# CITY OF ALBUQUERQUE

May 18, 2012

Re: **Diamond Mesa**  
**Grading and Drainage Plan**  
**Engineer's Stamp Date 5/01/2012 (N09/D012)**

Based upon the information provided in your submittal received 5/02/2012, the above referenced Grading plan can not be approved until the following comments have been addressed:

C2.02

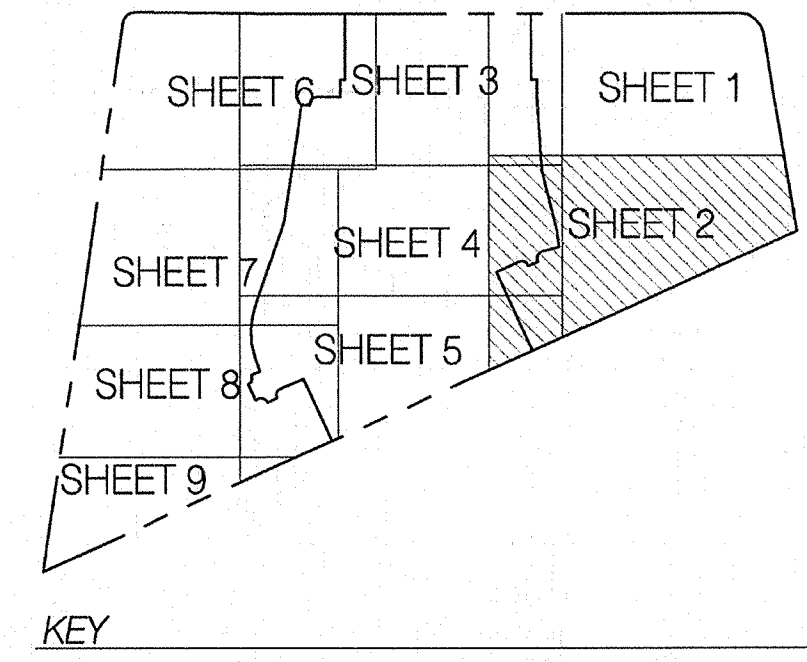
- AMAFCA's approval is required on the revised grading plan.
- Clearly show the Property Line. The Legend does not to match the plans.
- Include the Power Poles to the Legends.

- There are black solid circles throughout the plans in the driving lanes. Are these sanitary sewer manholes? Please clarify.
- There are bold dashed lines on the plans. Are these retaining walls?

- Please provide top of curb elevations along the streets. Are you maintaining 2% from the top of curb to Property line? Please double check the grades along the boundary to assure that proper slopes are maintained.

- Based on the grades shown along the easterly boundary the swale does not appear to have adequate depth. Some areas an elevation difference of more than 18" is called out and will required a retaining wall. Will the existing power poles be impacted by the proposed swale?

- Northeast corner of project is not fully. Please include the street improvements.
- The storm drain pipes have to be in placed and accepted prior to approval of additional building permits besides what has been approved previously.

- Show sidewalk culverts and sizes with invert elevations along Blake Road.
